Re: Seven Clover
3641 12th St NW
Site Plan
Architect's Stamp 8-27-23 (G14D062)

Based upon the information provided in your submittal received 12-4-23, the above referenced plan cannot be approved for Building Permit until the following comments are addressed:

AS101

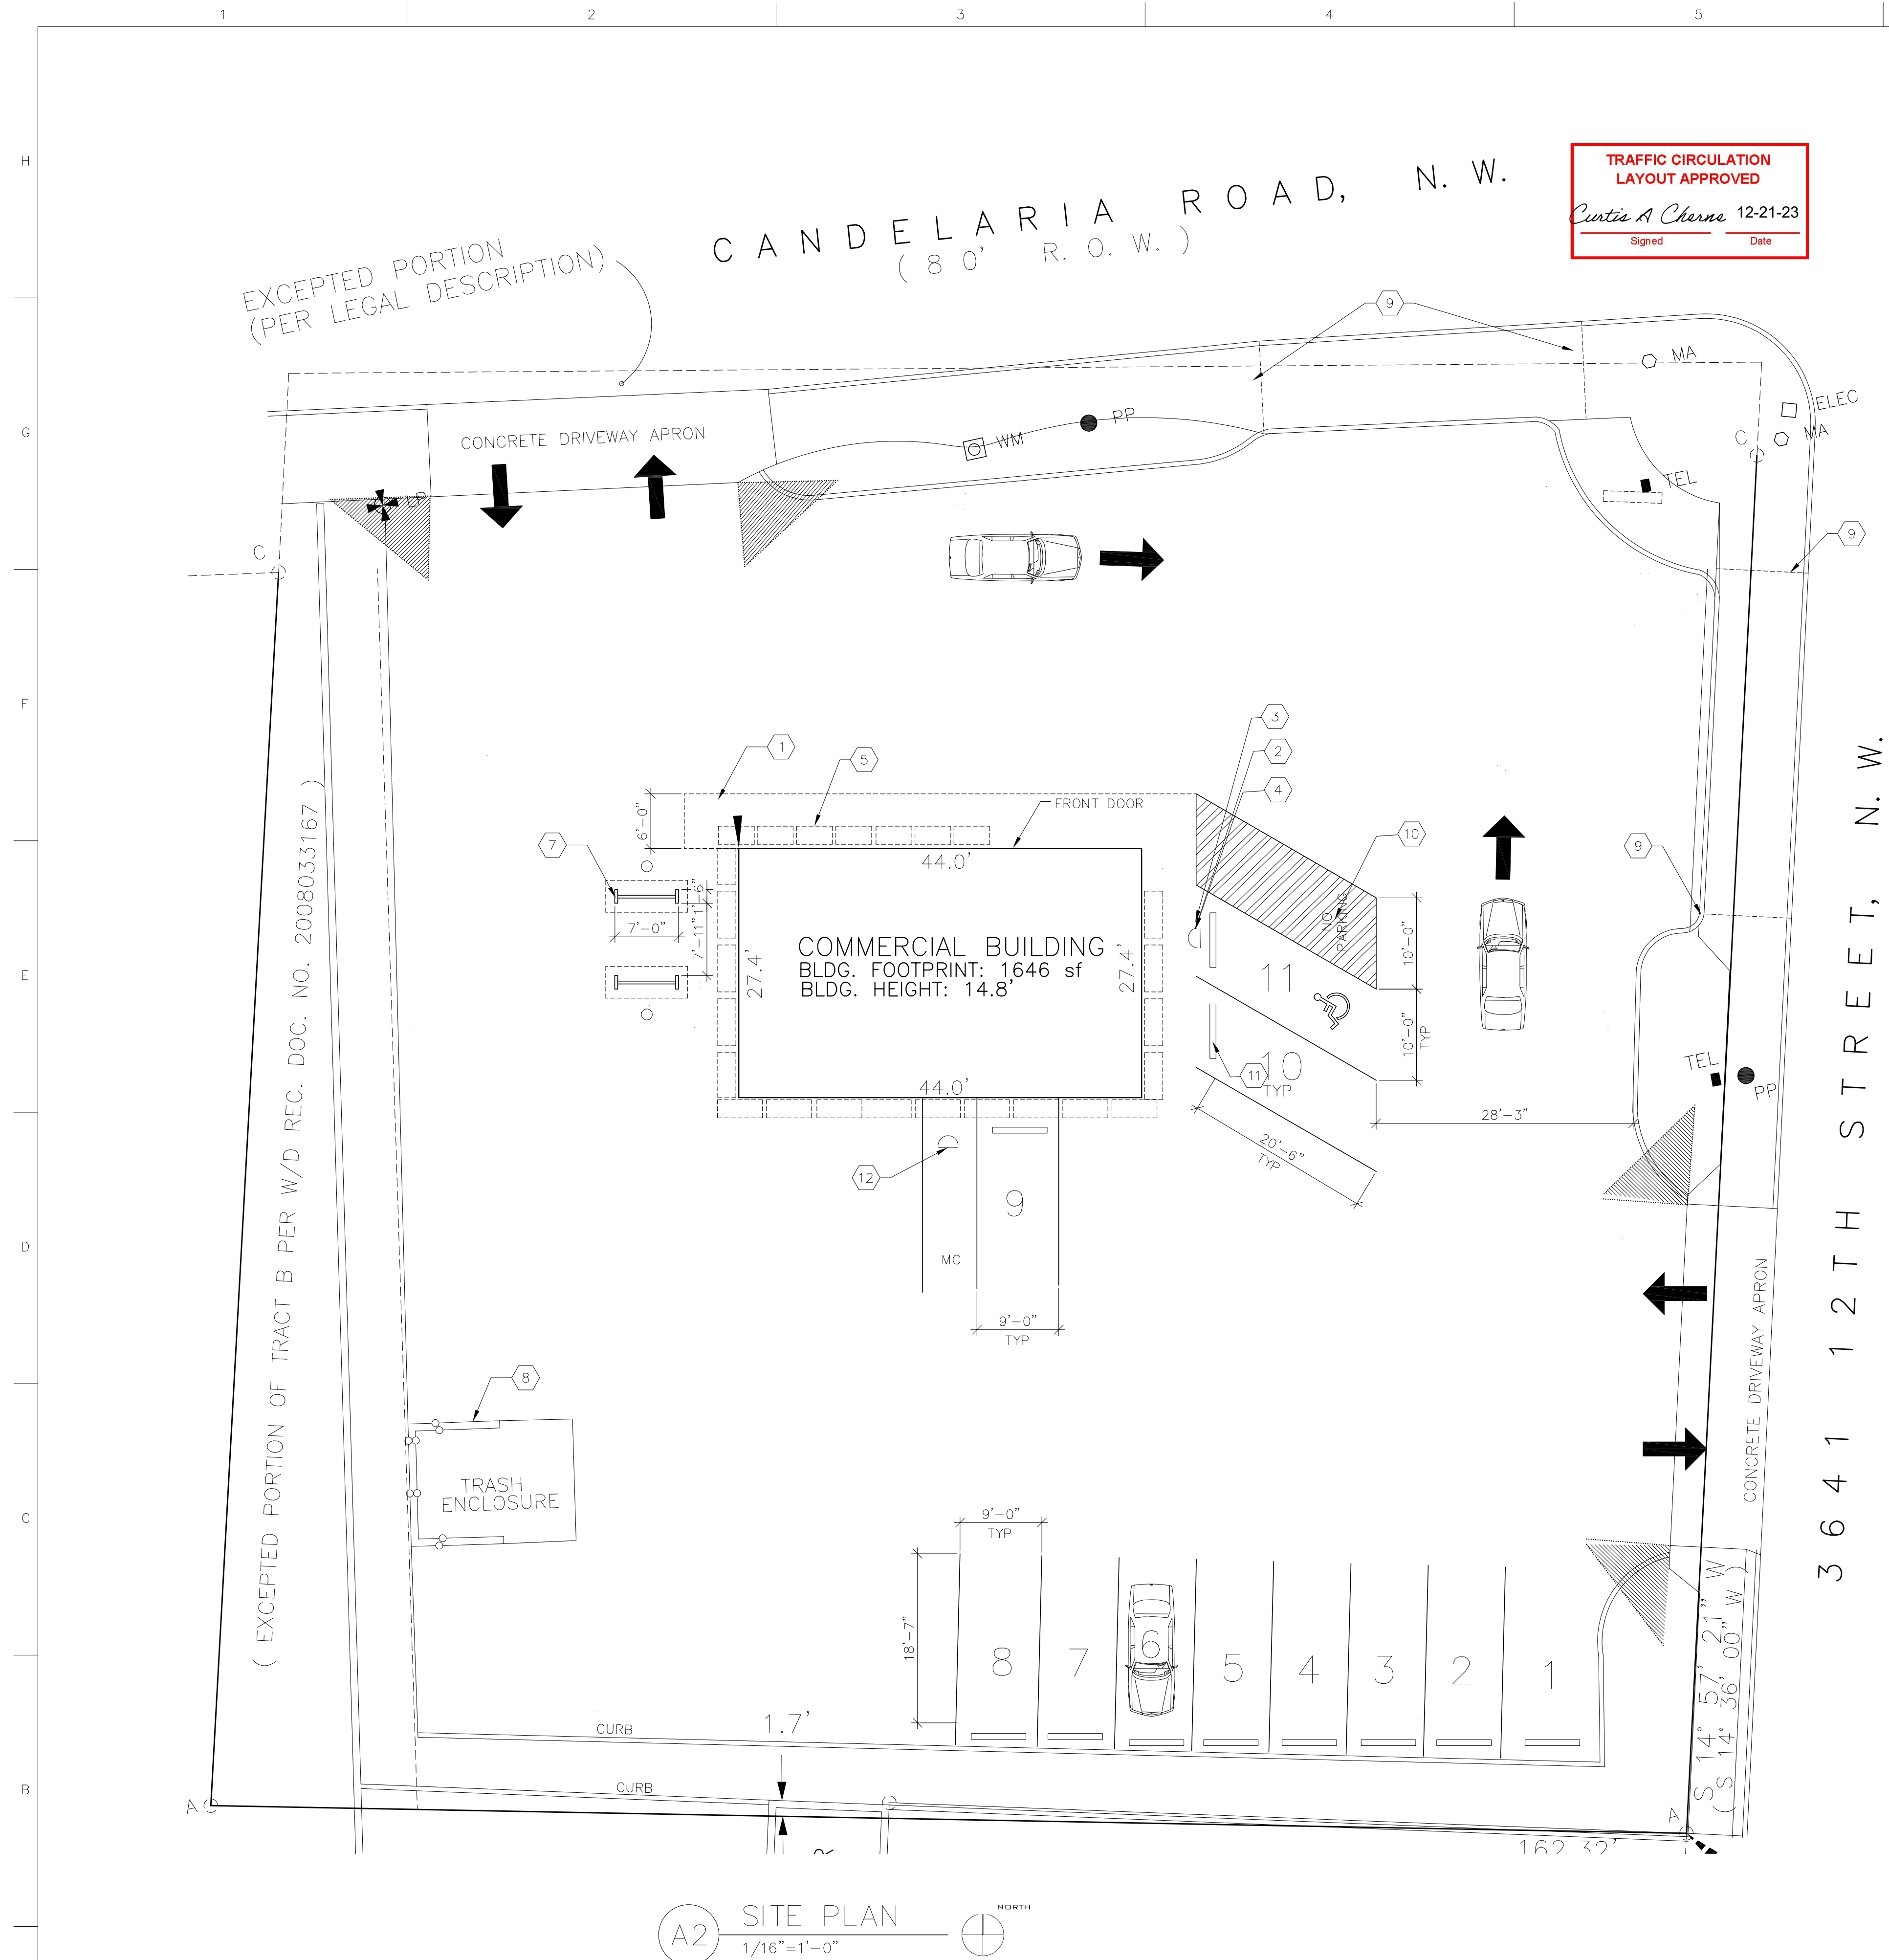
3. Provide the use of the building per the IDO, rather than "Commercial Building", so parking requirements are known.

4. Provide the required amount of parking and the provided amount of parking.

5. Show the location of the front door.

6. Please explain the purpose of Note 6 as it applies to this submittal or remove it.
Note 6 removed.
7. Show the mini clear sight triangles at both drive pads.

10. Provide the dimension for the angled parking, including the angle.
Dimension provided. Change is clouded with a delta 1
11. The drive aisle near the Candelaria entrance is labeled s 4'-9" wide. The minimum for 2-way traffic is 22 feet.
Parking removed from the front. ADA parking will be moved to the east side. Change is clouded with delta 1.

12. Show the 6' ADA accessible route from a City ROW to the front door.
ADA path noted. The change is clouded with a delta 1.
13. I could not locate the leader for Keyed Note 1.
Note updated to reflect existing 6' ADA path to remain. Change is clouded with a delta 1

14. It appears the leaders for Keyed notes 2,3 and 4 are for the handicap parking rather than for the motorcycle parking. For motorcycle parking you just need a motorcycle parking sign, which are 12" x 18" rather than the 12" x 12" as shown. Some designers put an "MC" in large letters at the entrance to the motorcycle parking stall.
Leaders moved to ADA parking. MC noted on motorcycle parking space. Change is clouded with delta 1

15. Handicap (HC) parking:
 - a. Signage: See image attached to the email. Remove non-compliant sign images "Reserved Parking".
Image inserted to drawing. clouded with delta 1.

- b. Note 2: refers to signage, where it should refer to a pavement marking. Recommend putting this in the Keyed Note area.
Note 2 moved to keyed note area. It is now Keyed note 10. change is clouded with delta 1

- c. HC parking should be near the front door.
HC moved to the front northeast parking spot. change is clouded with delta 1
 - d. Please add a length dimension to the HC parking stall.
Dimension added. Change is clouded with delta 1

- e. The HC sign should be in front of the parking space, rather than in front of th
Sign moved to front. Change is clouded with a delta 1.

Use changed on plan. Change is clouded with delta 1

Parking calcs provided on plan. Change is clouded with delta 1

Front door noted. Change is clouded with delta 1 marking the change.
